## Review Response

Project Name: Seda Dock & Bulkhead

Response To: Seda Dock (SHL23-015, SEP23-004)

EXISTING PLANT PLAN

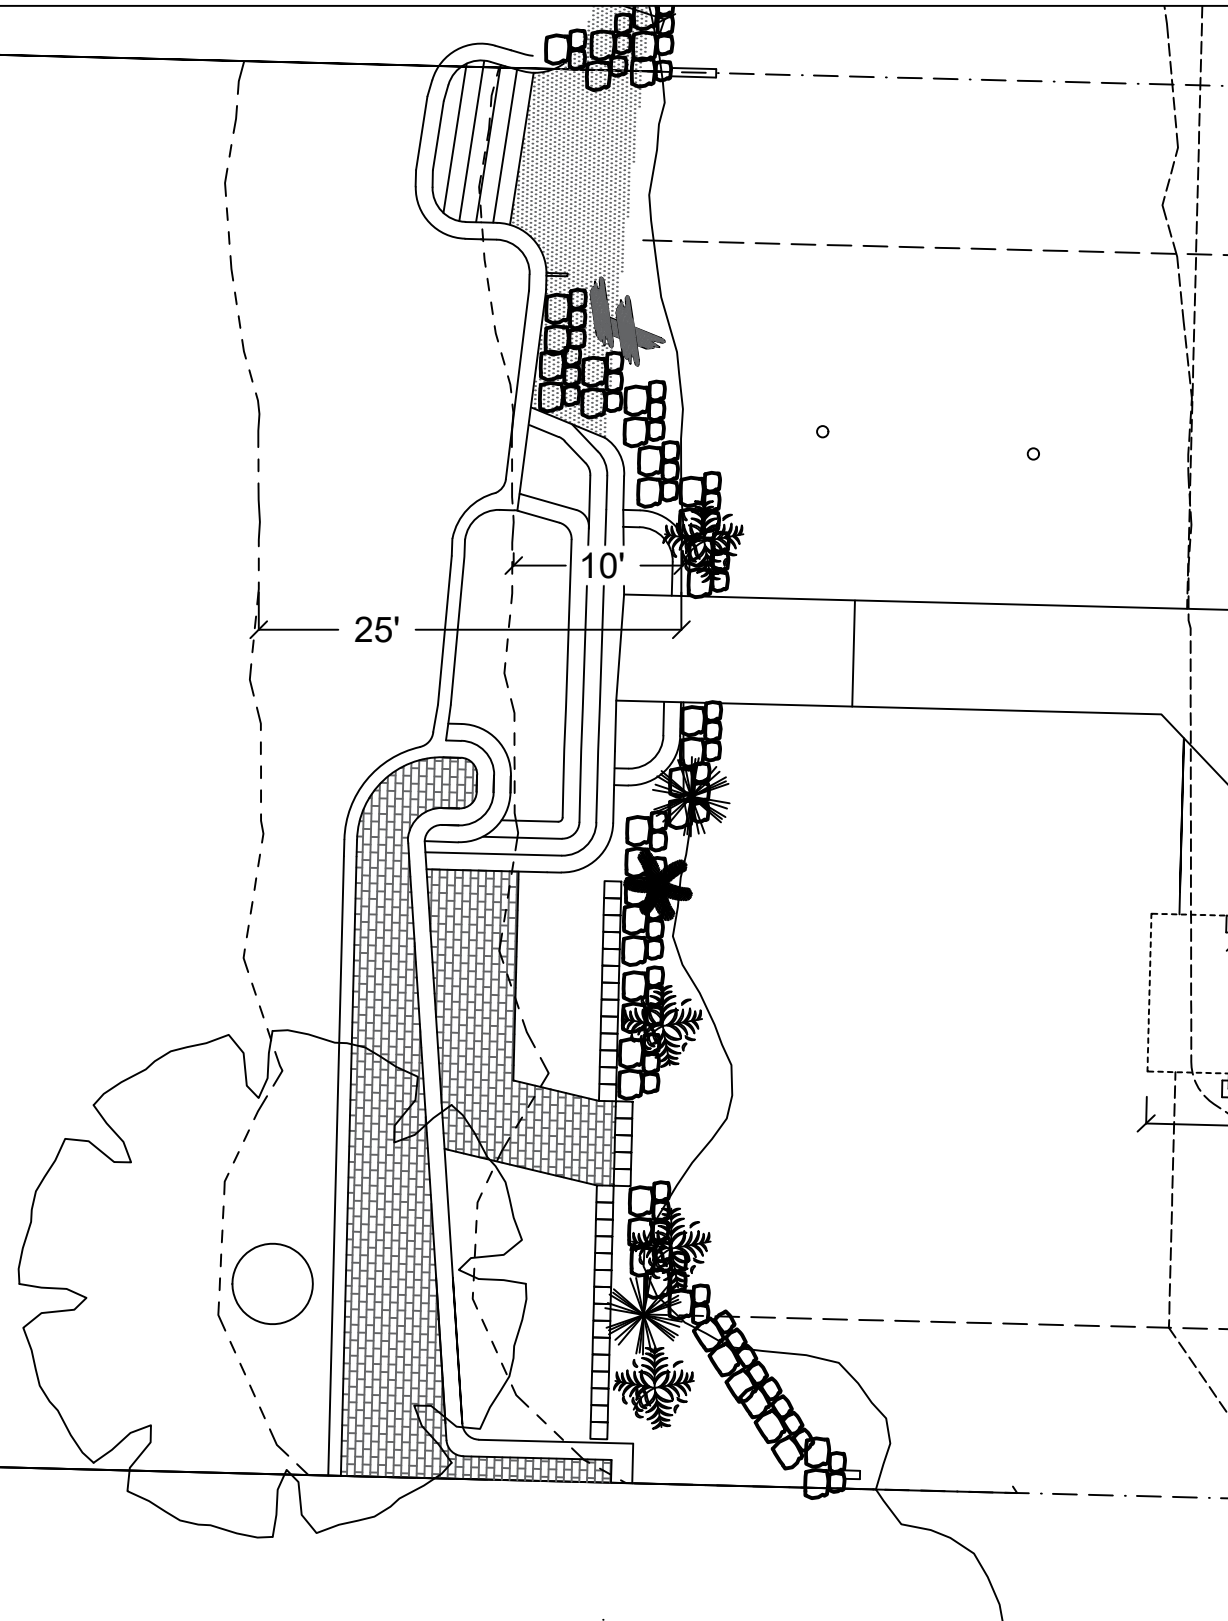
1. From aerial photos it appears regulated trees are in the area of work for the demolition of the bulkhead and walkways. Show all trees over 10" in diameter on the plan with tree protection fencing at their driplines or greatest extent possible.

**There is one oak tree located near the southern property line – it is several feet landward of the proposed demolition area, and care will be taken to protect it during the work. Pages A8 & A9 of the plan set have been updated to accurately reflect this. All other nearby trees shown in aerial photos are across the property lines and will not be impacted by the work.**
